**EXHIBITION OF ENVIRONMENTAL IMPACT STATEMENT
NEW EPPING SOUTH PRIMARY SCHOOL
86 CHELMSFORD AVENUE, EPPING**

Thank you for referring the Environmental Impact Statement (EIS) for SSD-8873789 'New Epping South Primary School' to Transport for NSW (TfNSW) for review and comment.

Figure 30 Proposed civil works to Grimes Lane (Source: PTC)

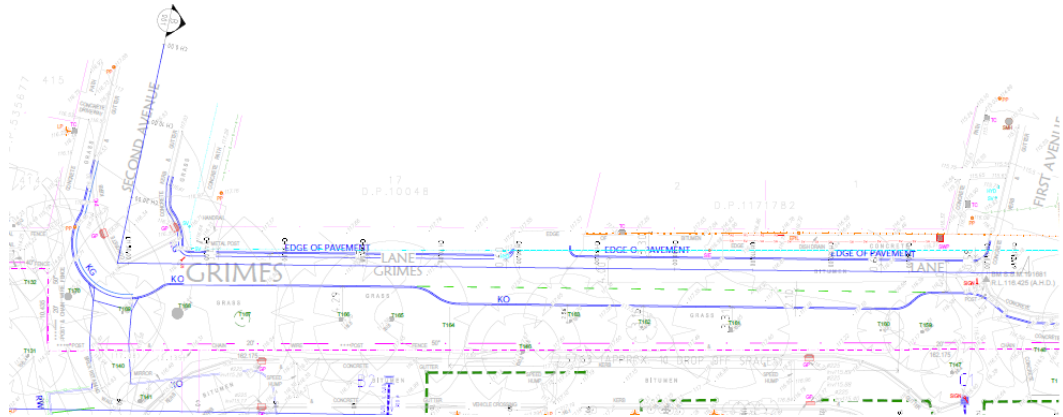
It is unclear whether buses (including coaches) can physically access the school and circulate in and out via Chelmsford Avenue and First Avenue. These services are not just confined to school bussing of students but also for the school's sport and excursion bus activities. TfNSW

- Confirm school arrangements regarding the above and confirm whether it's possible for buses and coaches are able to physically access the school and circulate in and out via Chelmsford and First Avenues. TfNSW recommends that swept path analysis for a 14.5m is conducted to determine whether a bus / coach can perform this operation via Chelmsford Avenue and First Avenue. This can be provided as part of the Response to Submissions (RtS).
